JPPC ref: MC/7504
Council ref: 22/03877/F

14th April 2023

Erection of three industrial buildings at Hatch End, Middle Aston

REV.	I - 19.04.23 - Application boundary amended		
PROJECT	Hatch End Industrial Estate, Middle Aston		
TITLE	Site Plan, Proposed		
SCALE	1:750 @ A3	DATE	25.07.22
DWG. NO.	2203.PR.03	REV.	I

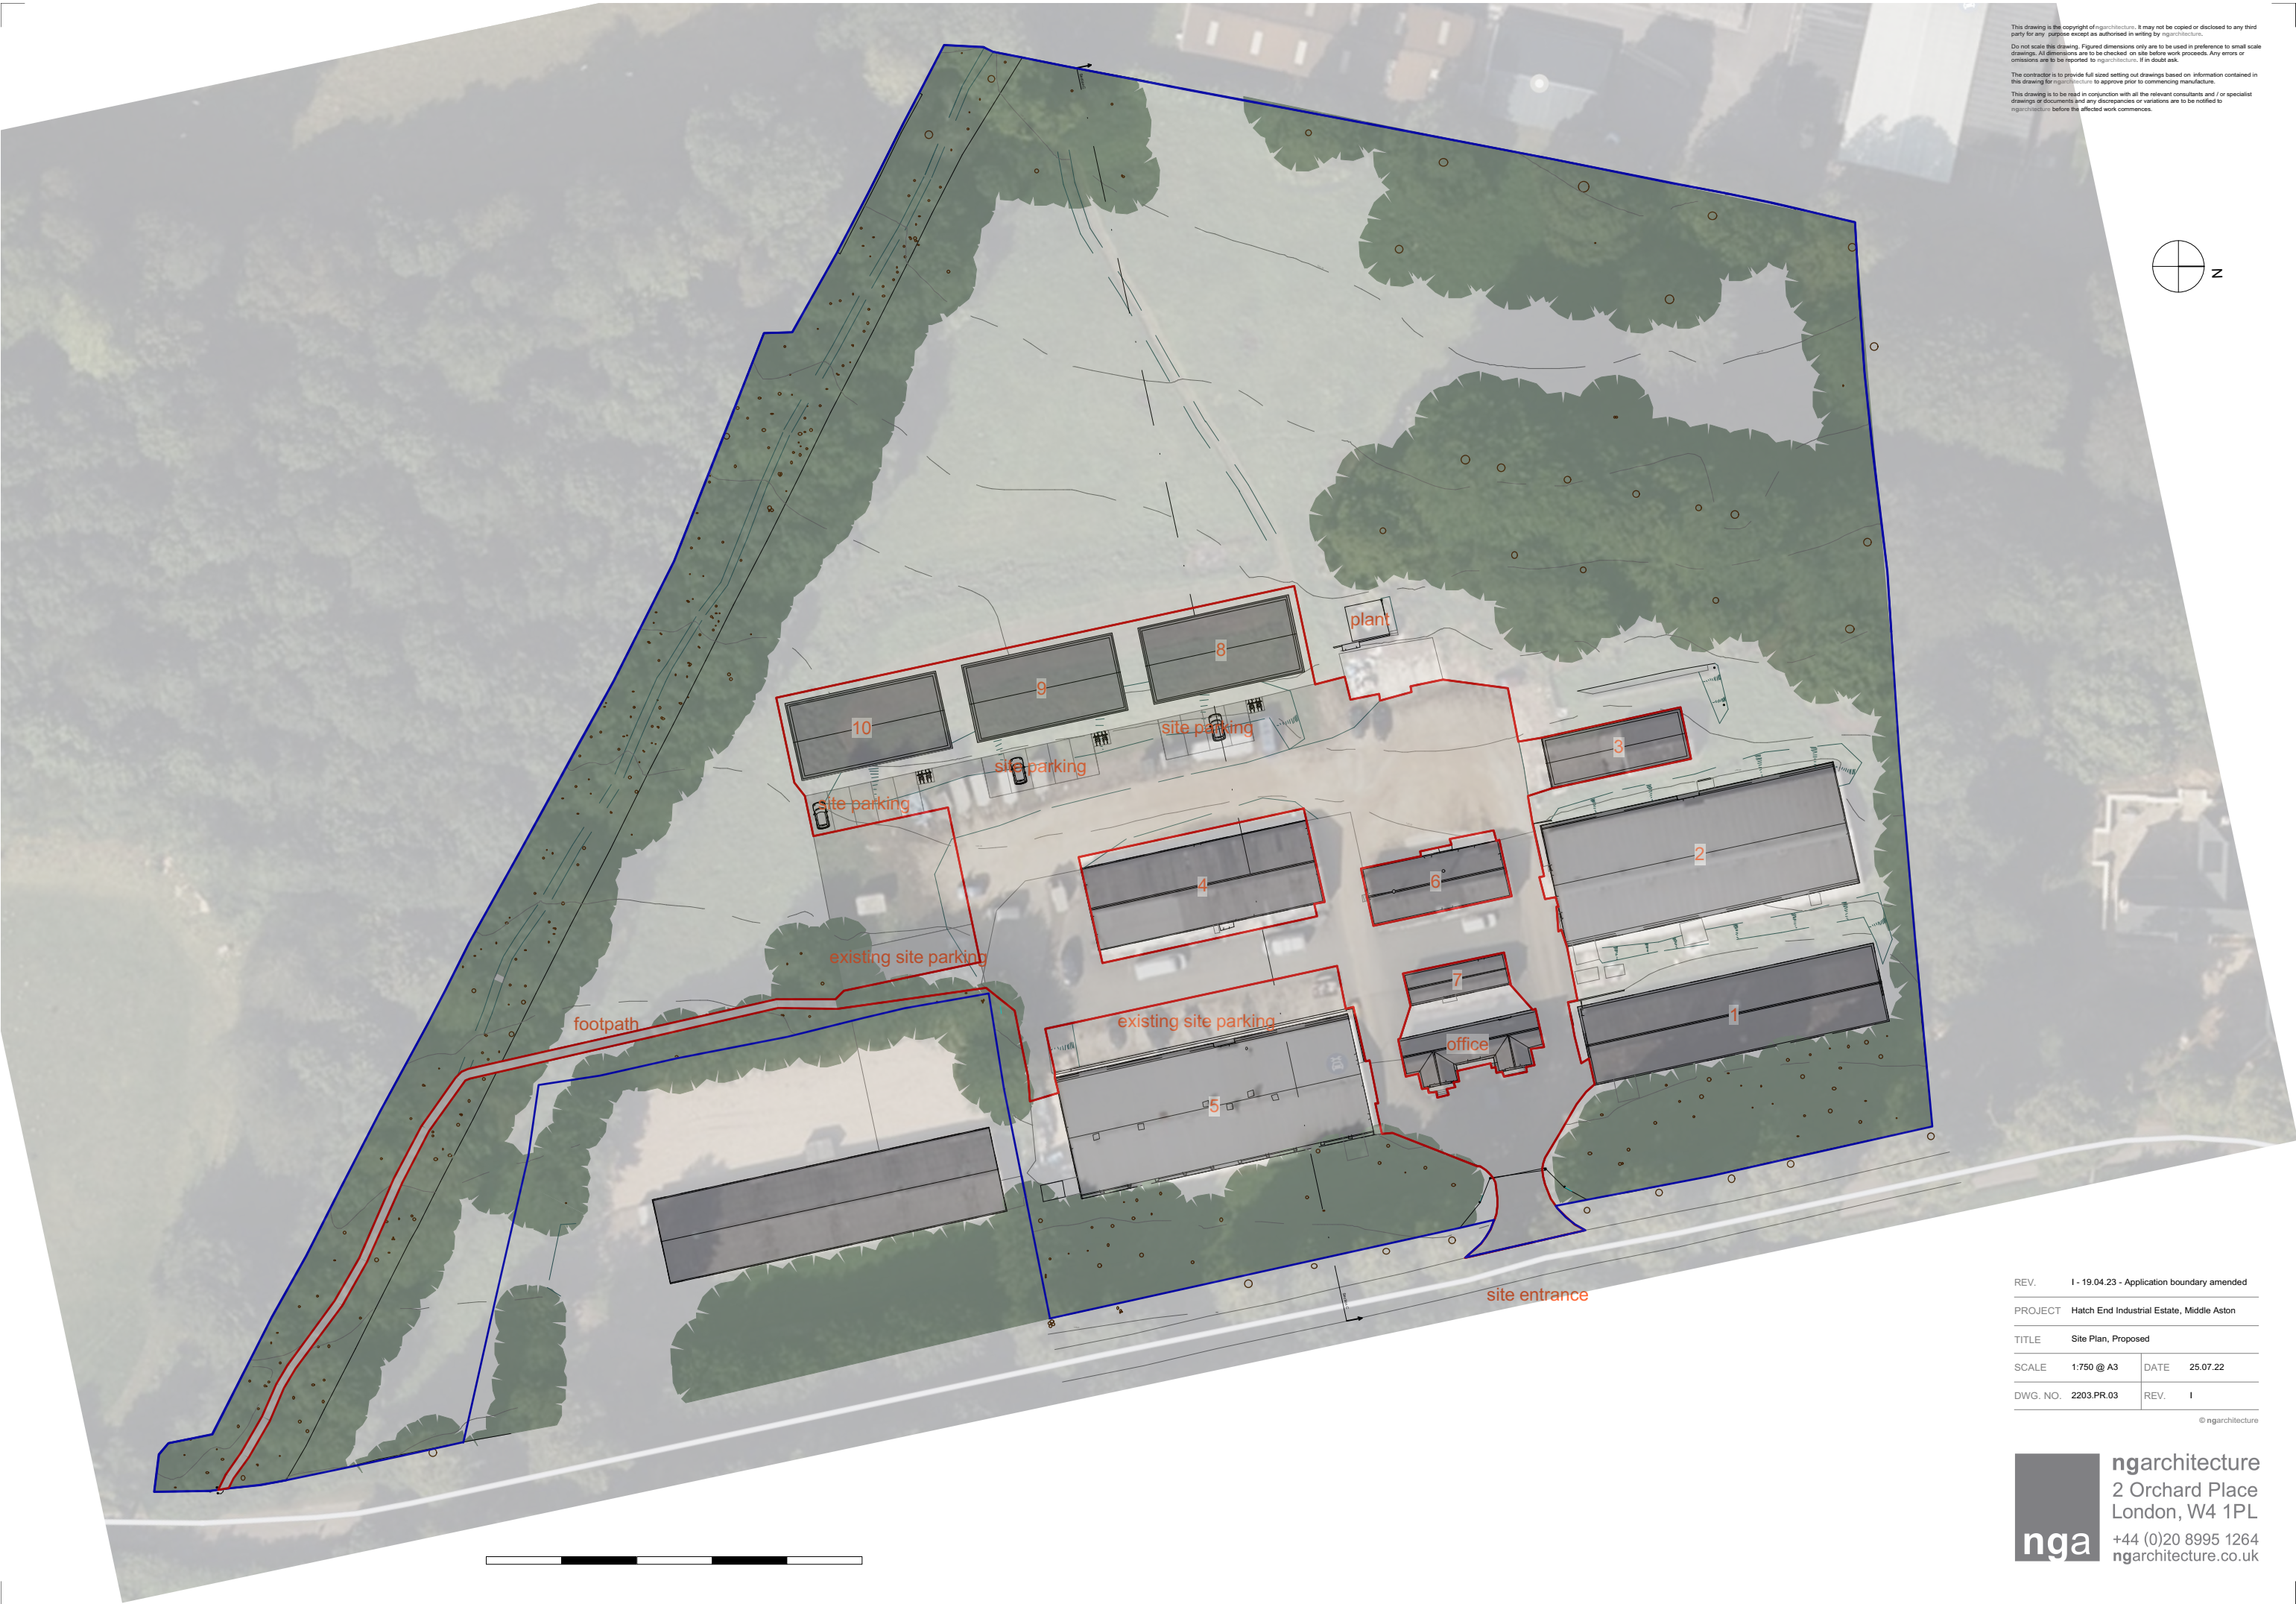
In the previously refused application, a footpath link was to be provided to Public Footpath 364/5/10 to the south and the plans for the current application have been amended to include this link as requested in the comments from OCC. This would provide improved links to the village compared to the existing situation. It is recognised that there is an increase in the footprint of buildings unlike the previous application, however as set out above this increase is minor in the context of existing buildings on the site.

The County Council have made comments regarding the level of car and cycle parking provision. It has been requested that following the adoption of the County's new parking standards, that the level of parking provision is reduced from 24 spaces is reduced to 14 spaces and that 10 cycle parking spaces are provided. The plans have been amended on this basis.

The County Council have raised concerns regarding the vehicle tracking for refuse vehicles that has been submitted. This tracking has been amended in line with the comments from the County Council.

- reduce the size of the red line to only include the areas of the site which are relevant to the proposed development (including the link to the public footpath to the south);
- reduce the amount of car parking;
- increase the amount of cycle parking; and
- amend the refuse vehicle tracking.

REV.	C - 19.05.23 - Boundary amended		
PROJECT	Hatch End Industrial Estate, Middle Aston		
TITLE	Location plan		
SCALE	1:1250 @ A3	DATE	04.10.22
DWG. NO.	2203.EX.01	REV.	C

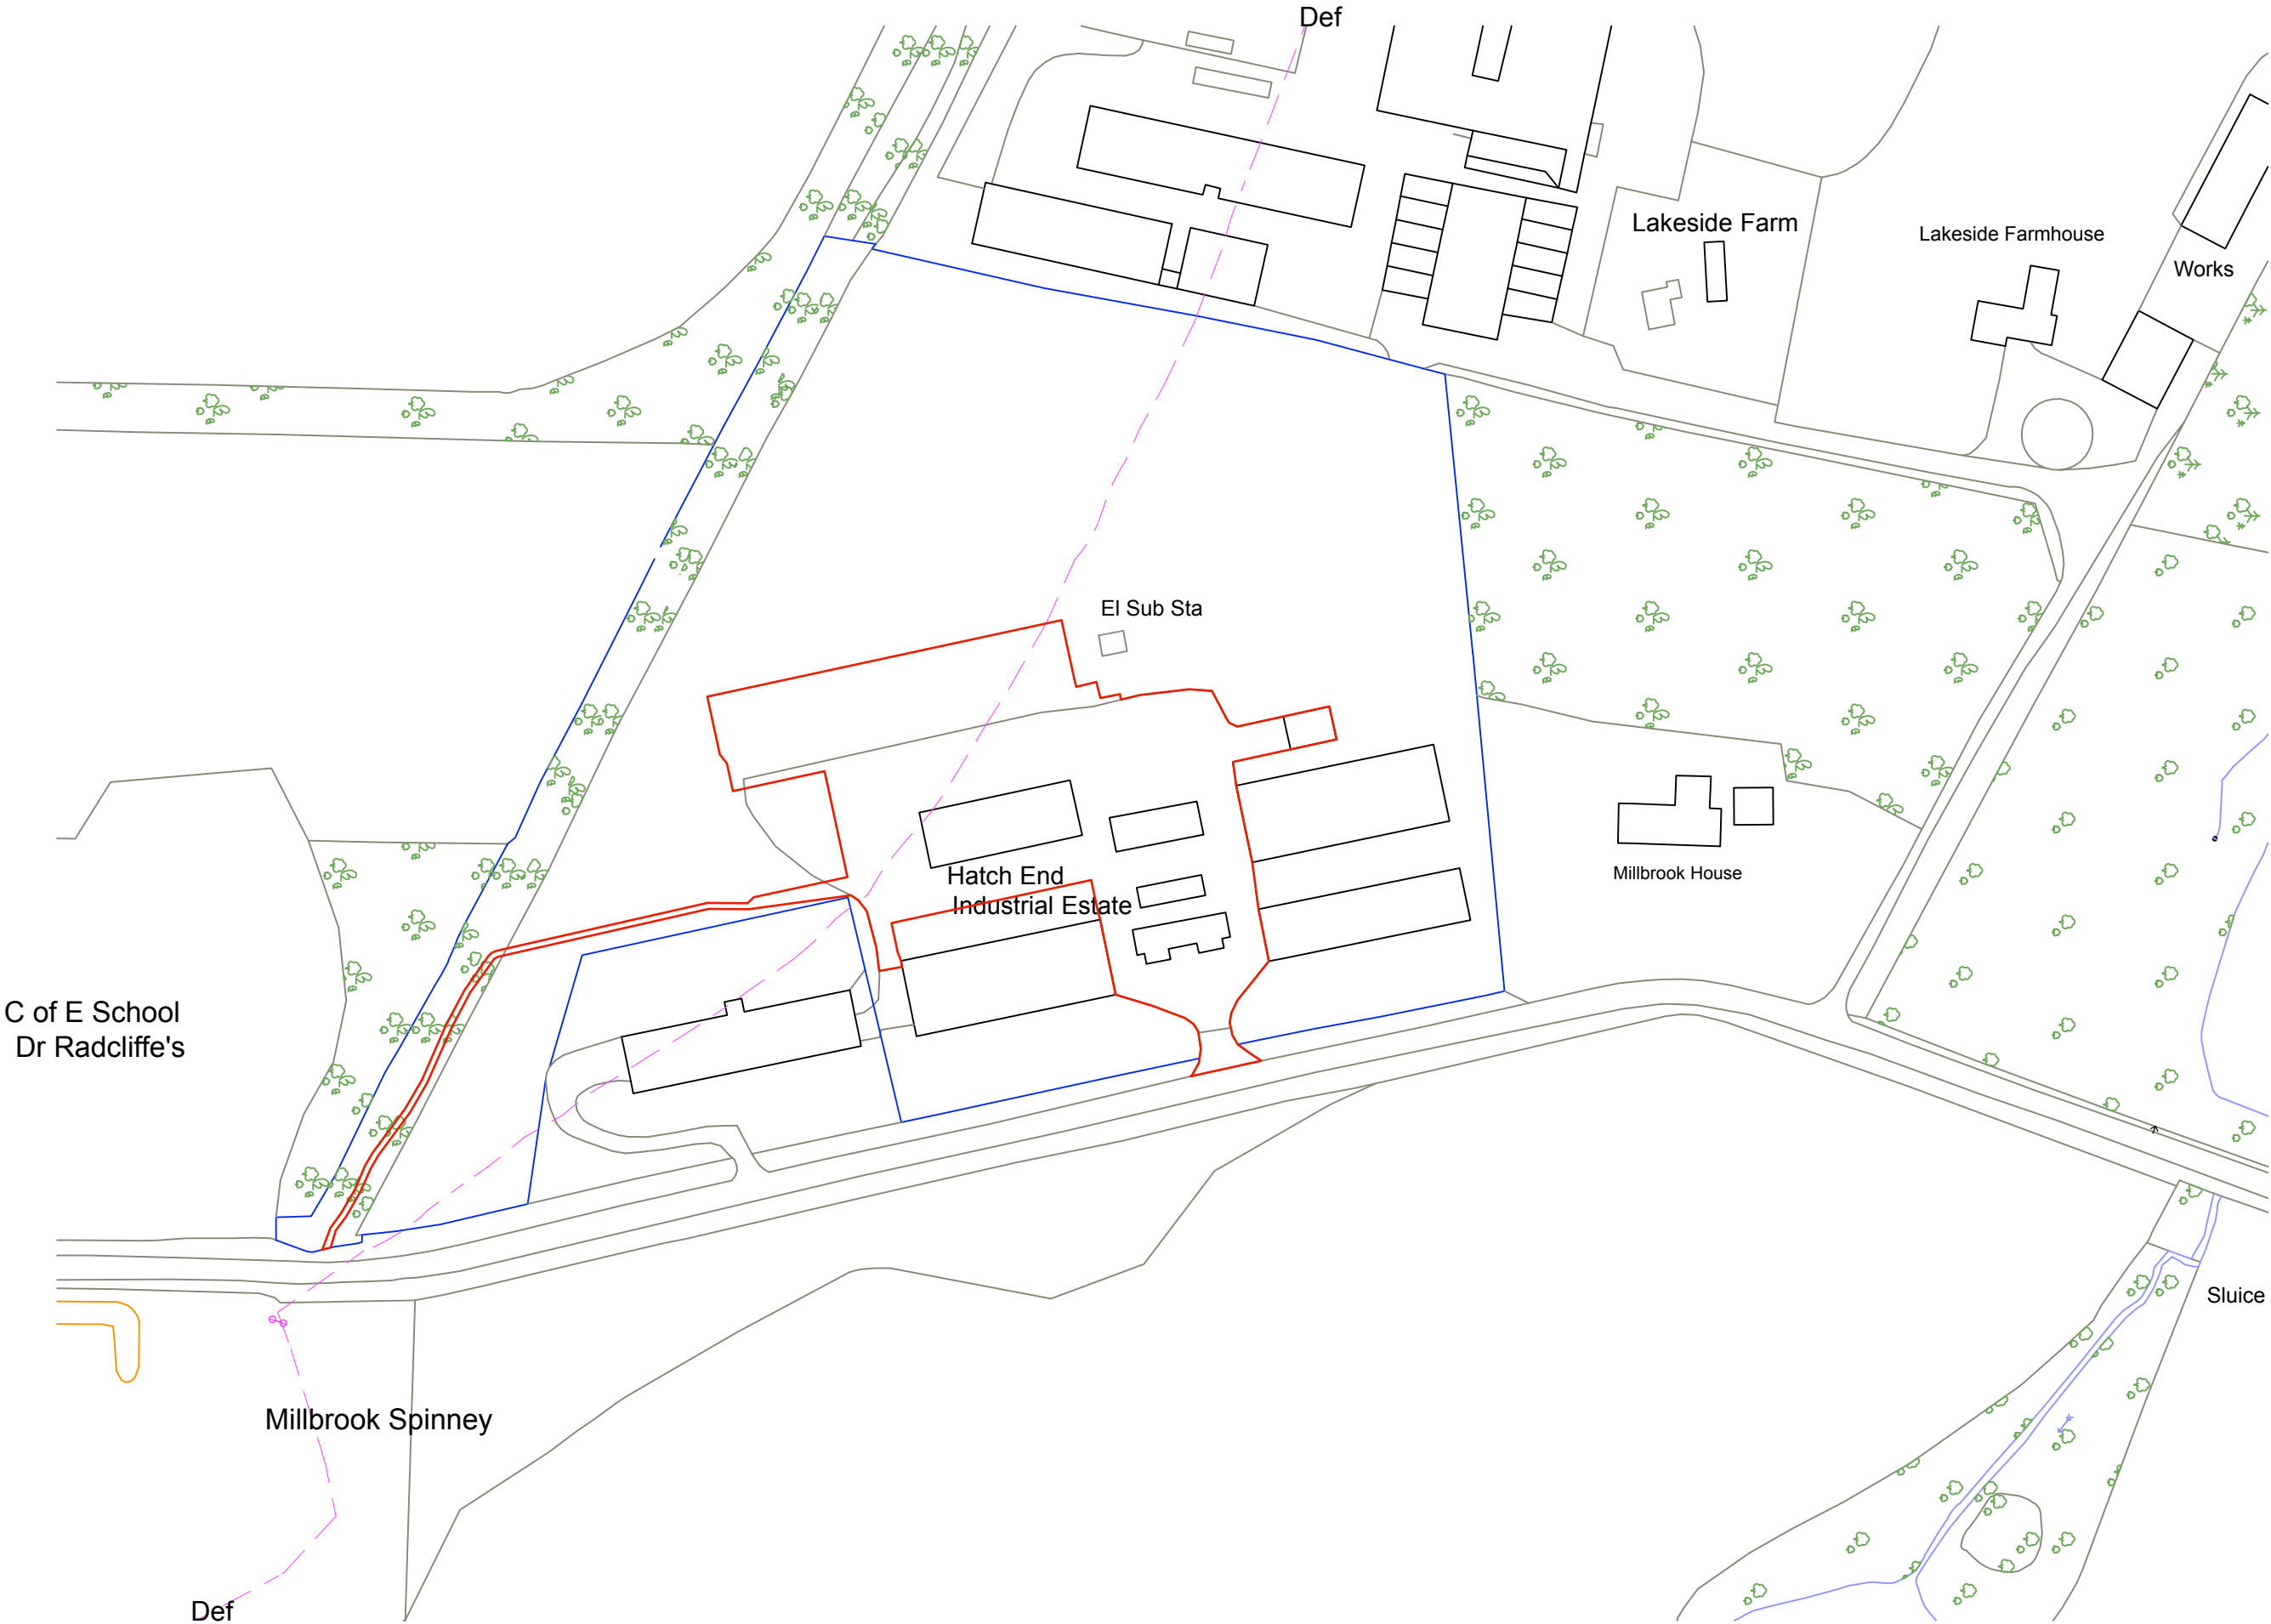
The site location plan has been reduced in size and the site area is now below 1 hectare. There is no requirement for Flood Risk Assessments on sites of less than 1 hectare in size in Flood Zone 1. A drainage strategy for the development can be conditioned.
